**KIRKLEES METROPOLITAN COUNCIL  
INVESTMENT & REGENERATION SERVICE**

Reference No:	<b>2024/62/92383/E</b>
Site Address:	5, Chestnut Avenue, Staincliffe, Batley, WF17 7DH
Description:	Demolition of existing garage and erection of two storey side and rear extensions and single storey front extension
Recommending Officer:	Elenya Jackson

**DECISION - REFUSED**

## **OFFICER REPORT**

Drg No 24 90/B Rev

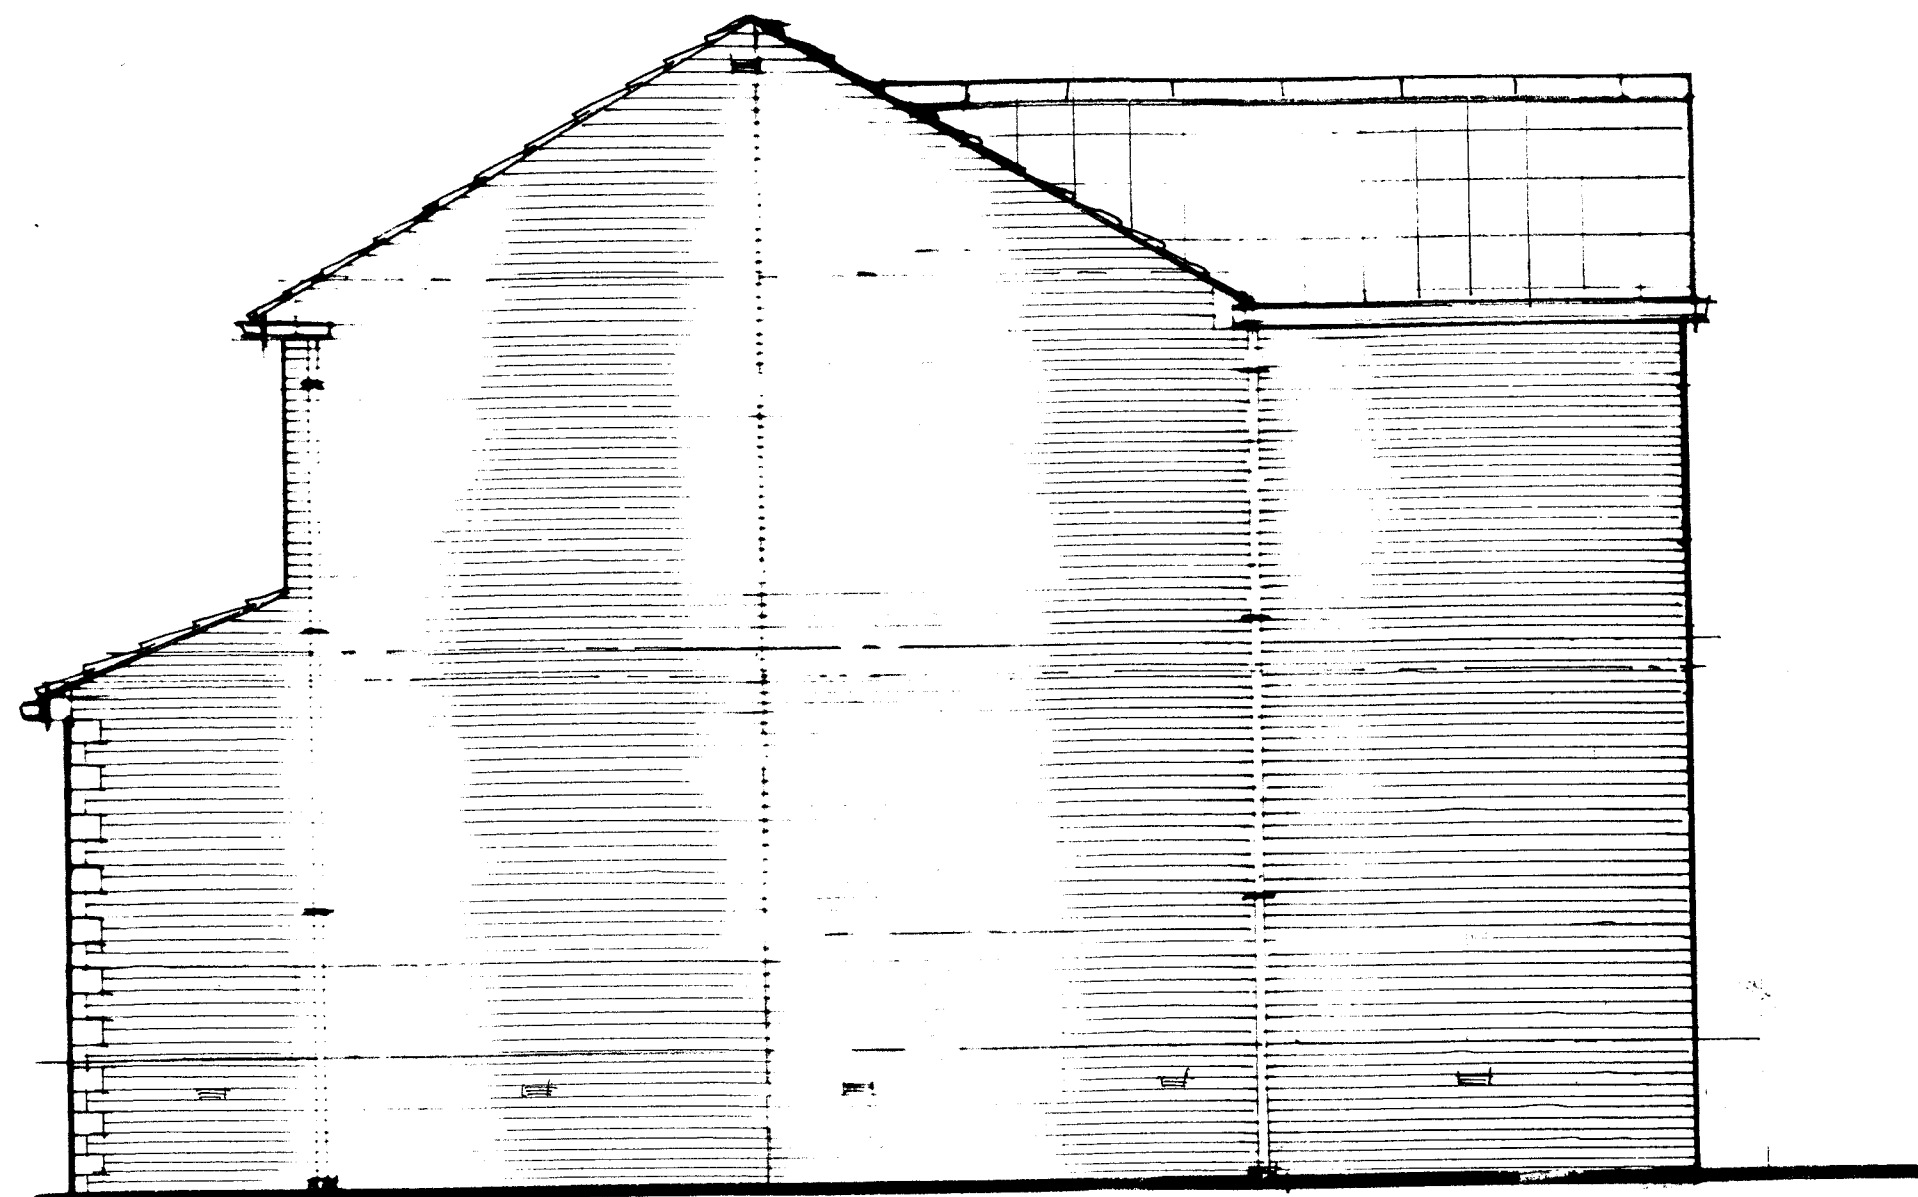
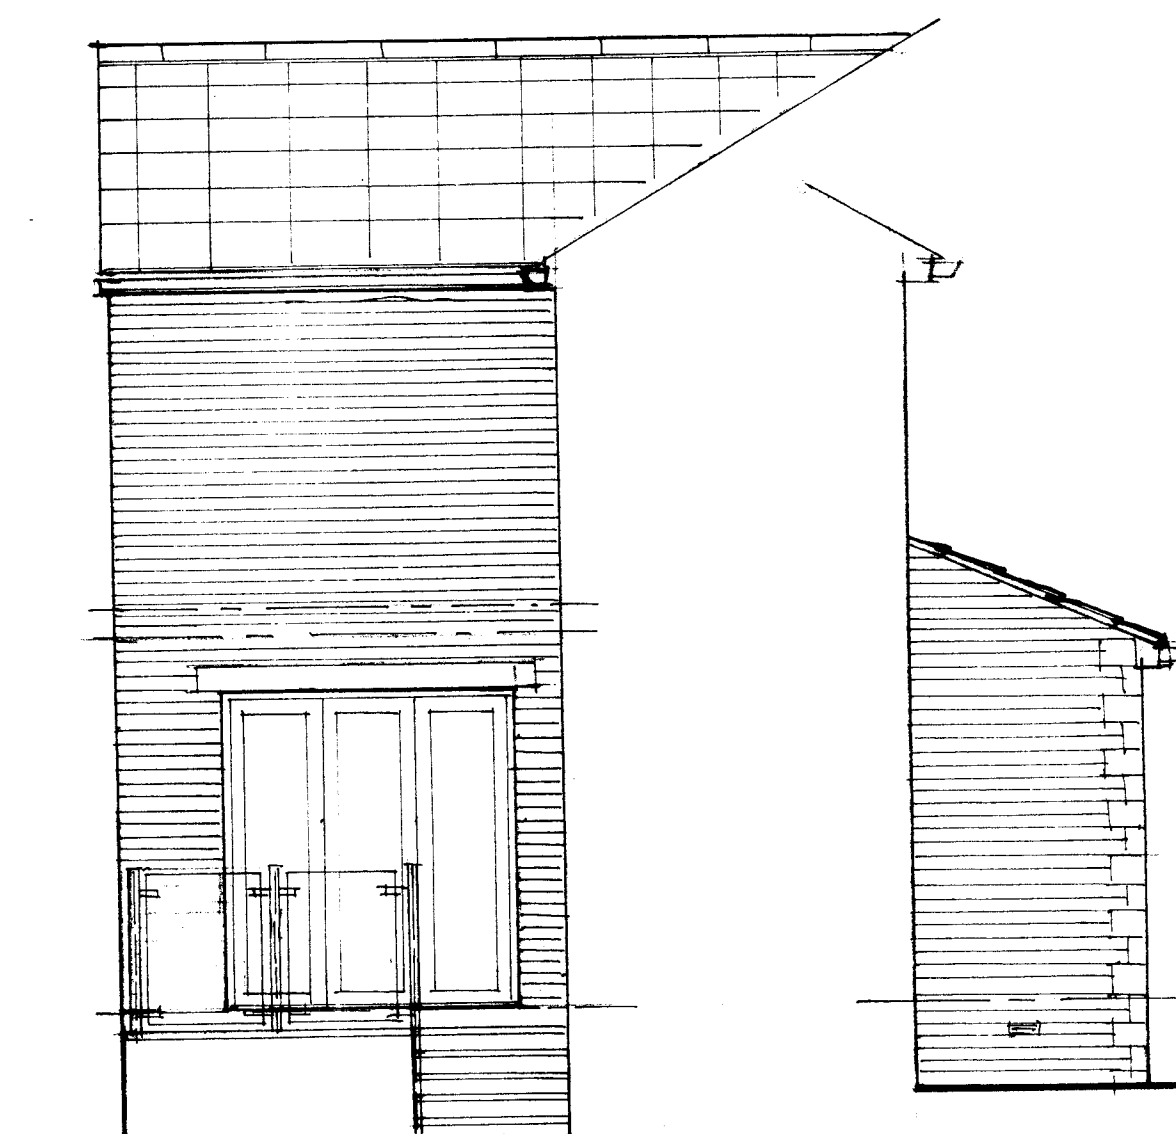
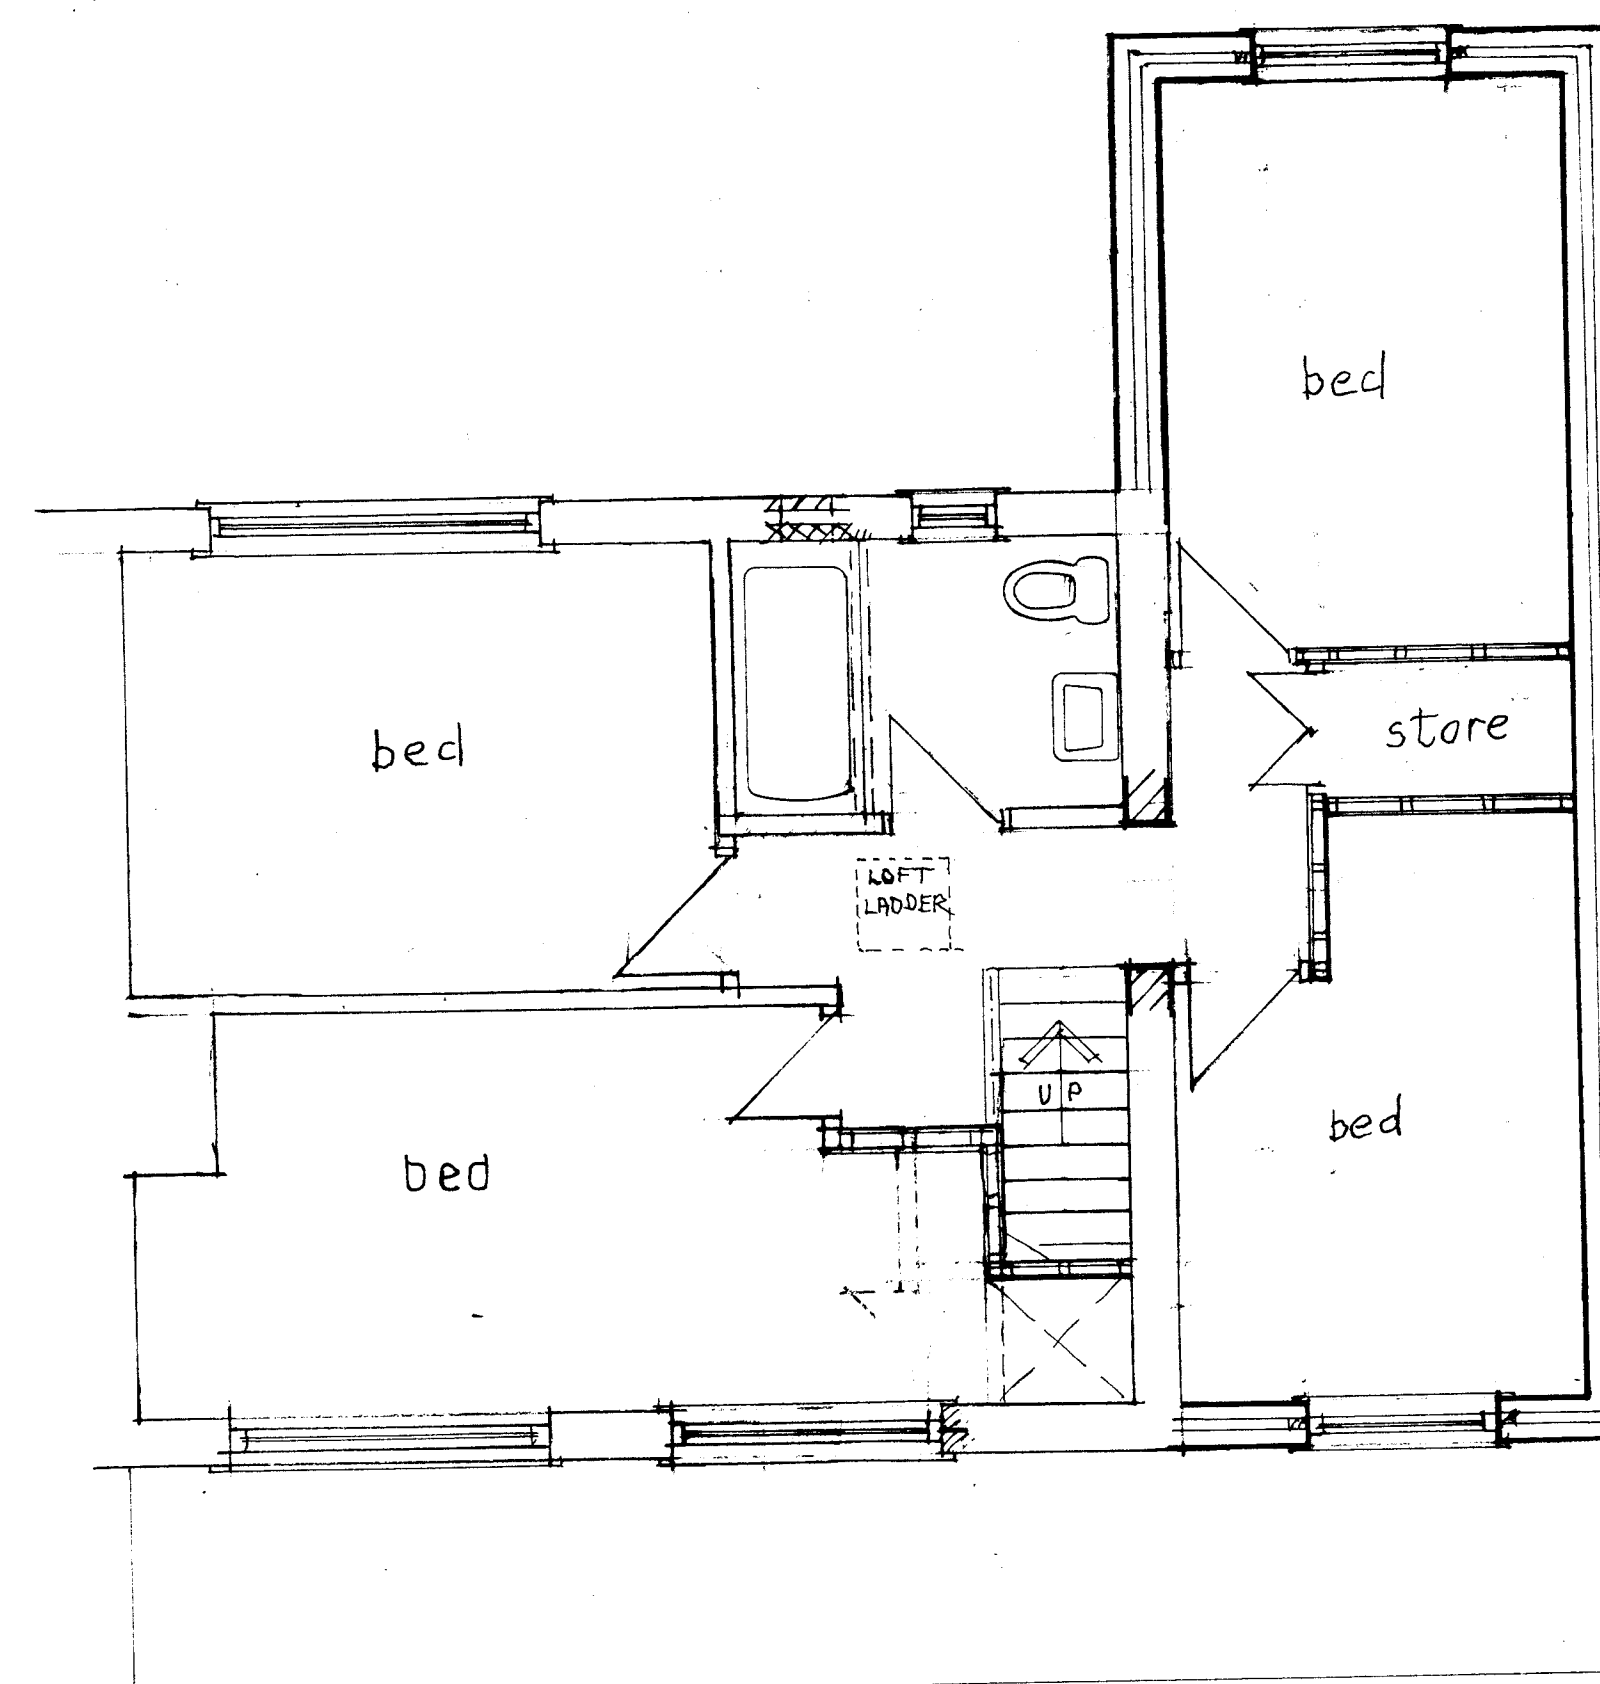
The proposed side extension would have a width of 3m, a depth of 9.4m, a maximum height of 7.7m and an eaves height of 5.8m. The proposal would not be set down and set back from the host dwelling.

The single storey front extension would project 1.6m beyond the front elevation of the dwelling with a maximum height of 3.6m and an eaves height of 3.1m.

Officers acknowledge that, the proposed extension would not be set down and back from the host dwelling and would be constructed in close proximity to the boundary of the site thereby not meeting the SPD. Officers have viewed the immediate vicinity of the site, No.3 and no.1 (a semi-detached pair) have extensions of a similar scale to the proposal.

It is considered that, the introduction of a two storey side extension would interrupt the spacing of the street scene and create an unacceptable terracing effect from no.1 to no.7 Chestnut Avenue. It is considered that the proposed two storey extension would therefore fail to respect the character of the street scene or prevailing character of the area.

Overshadowing/loss of light/overbearing: There is one side facing window which relates to the living room of no.3. The proposal would introduce a two storey blank elevation parallel to a single aspect ground floor living space. It is considered that this would result in an unacceptable impact on the living conditions of current and future occupiers of this property.

1. The proposed extension, by virtue of its scale, massing and close proximity to a shared boundary, would result in an overbearing and overshadowing impact to the side facing living room window at 3 Chestnut Avenue detrimentally impacting on the residential amenity of current and future occupiers of this property. To permit this development would be contrary to Policy LP24 of the Kirklees Local Plan, KDP1 & KDP2 of the House Extensions and Alterations SPD and advice within Chapter 12 of the National Planning Policy Framework.

1. The two storey side extension proposed would take up most of the space to the side of the house coupled with the the lack of set down and back would result in an unacceptable terracing effect. As such it would close a gap between the houses eroding the sense of space between houses which is a positive characteristic of the street scene. This does not promote good design and is contrary to LP24 of the Kirklees Local Plan and design guidance given in sections 4.1, 4.2, 4.3, 5.19, 5.20 & 5.21 of the Kirklees House Extensions Supplementary Planning Document.
